Planning Department
Alan Varela, Director

June 3, 2024

**Re: General Atomics Office
14820 Central SE
Traffic Circulation Layout
Engineer's/Architect's Stamp 5-24-2024 (L23D011A)**

A3 SITE PLAN
1" = 20'-0"

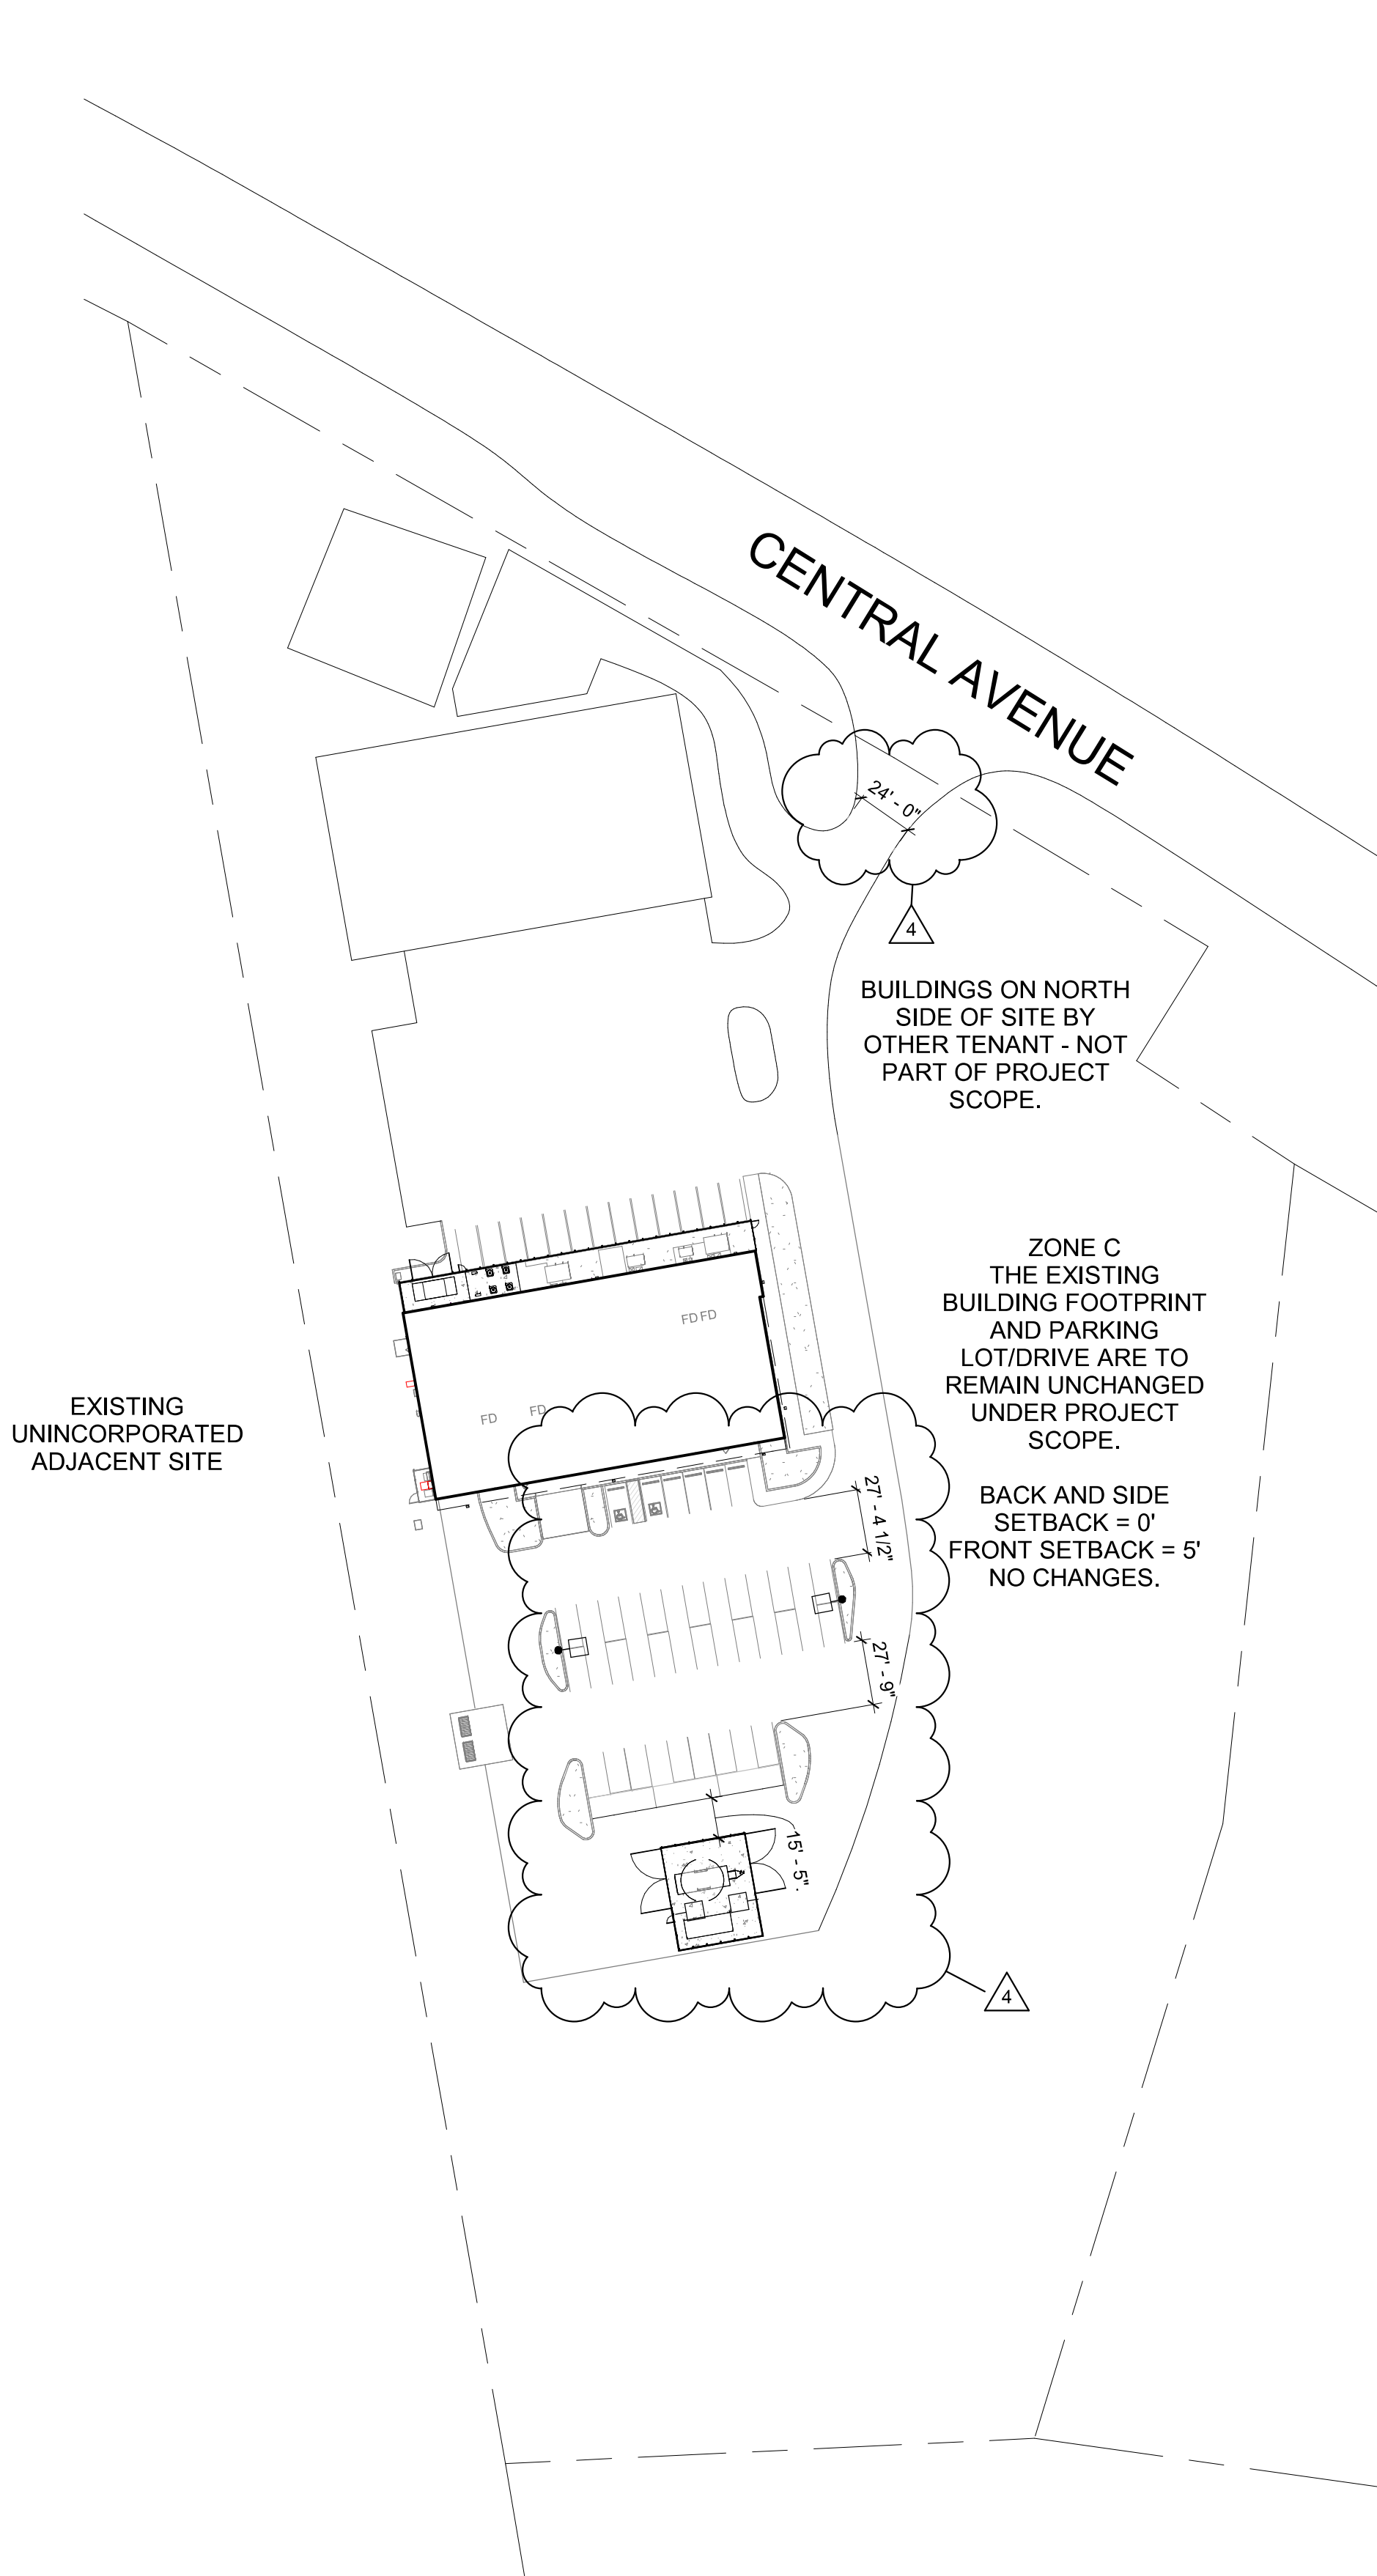
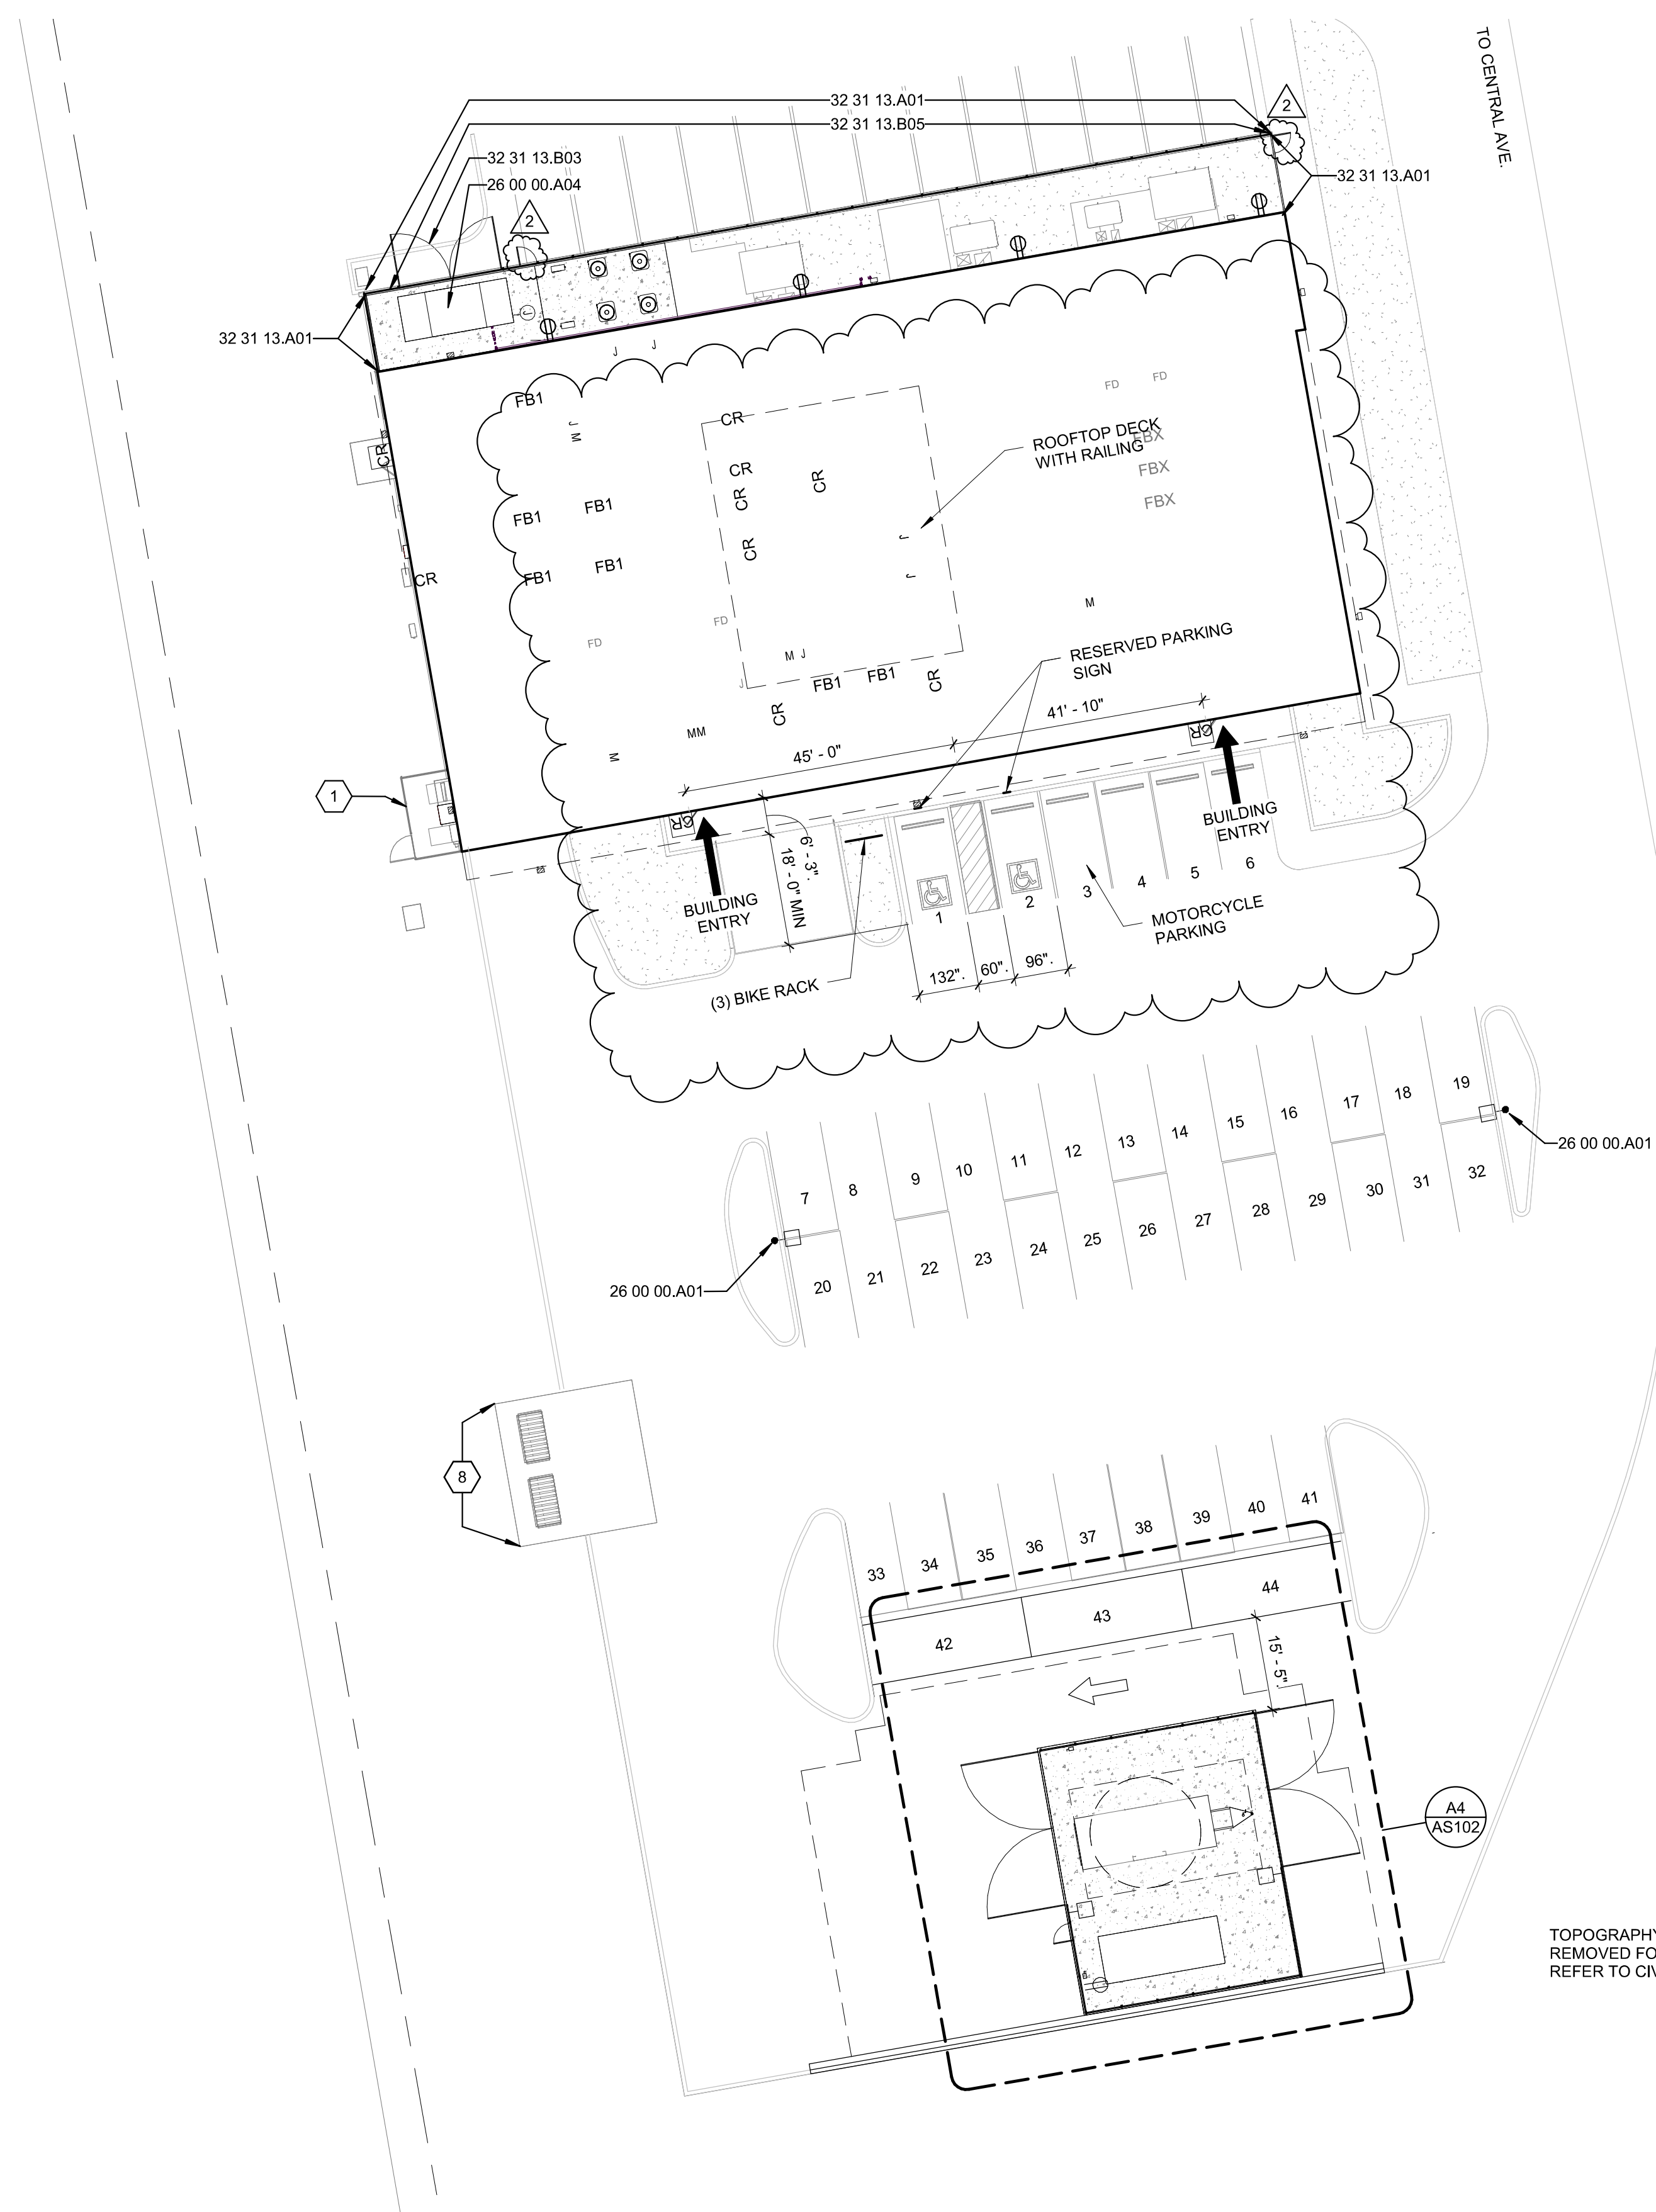
1. Please show a vicinity map on sheet AS101 showing the location of the development in relation to streets and well known landmarks.
2. In the parking list indicate that one of the two ADA spaces should be for van.
3. All accessways to the site from the adjacent roadway shall be ADA-compliant.
4. Please list the width and length for all existing and proposed parking spaces. Some dimensions are not shown.
5. The minimum parking stall dimensions are:

6. The ADA accessible spaces must include an access aisle. Van accessible aisles should be 8ft wide; all others should be 5ft wide.

7. ADA curb ramps must be updated to current standards and have truncated domes installed.
8. Motorcycle parking spaces shall be designated by its own conspicuously posted upright sign, either free-standing or wall mounted per the zoning code.
9. All bicycle racks shall be designed according to the following guidelines:
 - a. The rack shall be a minimum 30 inches tall and 18 inches wide. Show your details.
 - b. The bicycle frame shall be supported horizontally at two or more places. Comb/toaster racks are not allowed.
 - c. The rack allows varying bicycle frame sizes and styles to be attached.
10. Bicycle racks shall be sturdy and anchored to a concrete pad.
11. A 1-foot clear zone around the bicycle parking stall shall be provided.

12. Bicycle parking spaces shall be at least 6 feet long and 2 feet wide.

13. Show all drive aisle widths and radii. Some dimensions are not shown.

15. List radii for all curves shown; for passenger vehicles. Radius for delivery trucks, fire trucks, etc. is 25 ft. or larger.
16. Per the DPM, a 6 ft. wide ADA accessible pedestrian pathway is required from the public sidewalk to the building entrances. Please clearly show this pathway and provide details.
17. Per DPM, a 6 ft. wide ADA accessible pedestrian pathway is required from the ADA parking stall access aisles to the building entrances. Please clearly show this pathway and provide details.

20. All one-way drives shall have "One Way" and "Do Not Enter" signage and pavement markings. Please show detail and location of posted signs and striping.

21. Show the clear sight triangle and add the following note to the plan: "Landscaping and signage will not interfere with clear sight requirements. Therefore, signs, walls, trees, and shrubbery between 3 and 8 feet tall (as measured from the gutter pan) will not be acceptable in the clear sight triangle.
